# **KITITAS COUNTY**

### **MEMORANDUM**

TO: Community Development Services  
FROM: Public Works Planning Review Team  
DATE: March 19, 2021  
SUBJECT: CU-21-00002 Sweetwater Ranch

#### **Public Works Conditional Use Comments**

# SITE PLAN

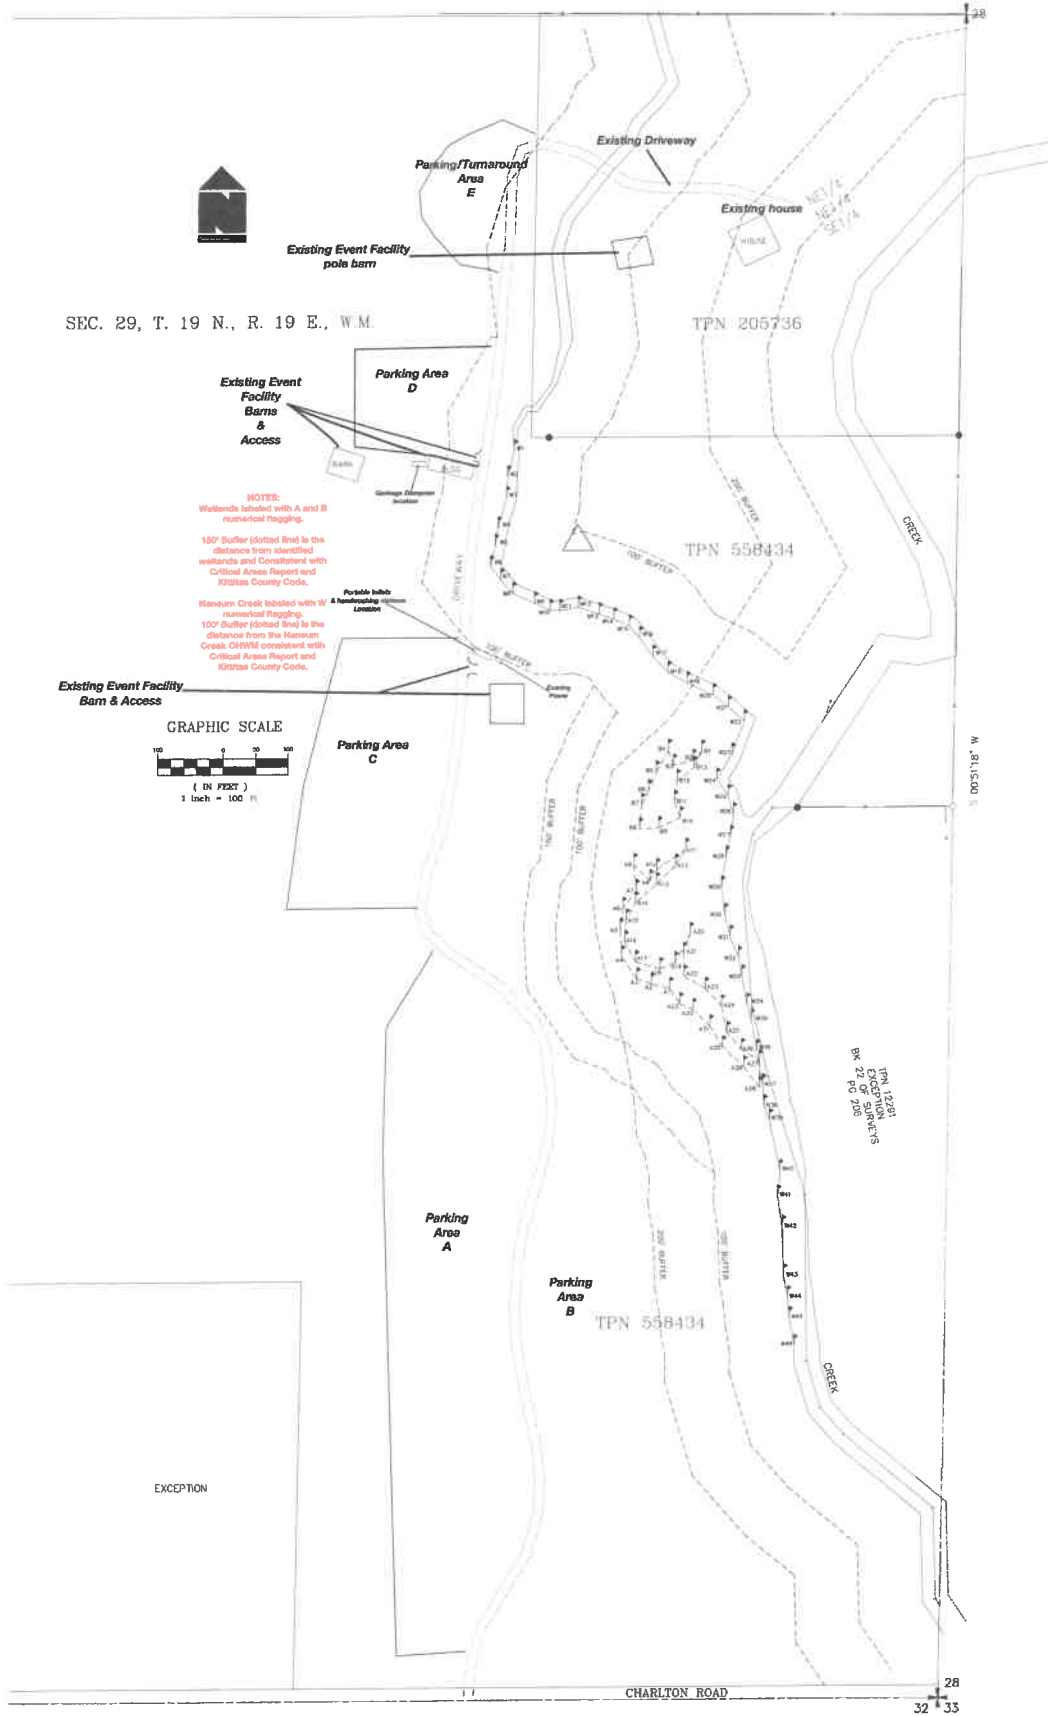
- The entrance to the property shall be clearly marked during events.
- An access permit is required to ensure the access meets Kittitas County Code and International Fire Code. The access road shall be a minimum of 20 feet wide and have an acceptable fire apparatus turnaround.

- A portion of the properties included in this project are located within the 100-year floodplain. At this time a flood plain development permit is not required for the proposed project. If possible, any future development should remain outside of the floodplain in order to reduce risk and avoid mandatory flood insurance purchase requirements. All activities within the floodplain require a floodplain development permit. All construction, including structures that are exempt from a building permit, must follow the guidelines within KCC 14.08. Note that the floodplain information from FEMA is based on an approximate study. Please contact the Floodplain Manager at Public Works (509-962-7690) with any questions regarding the floodplain on these parcels and permitting questions.
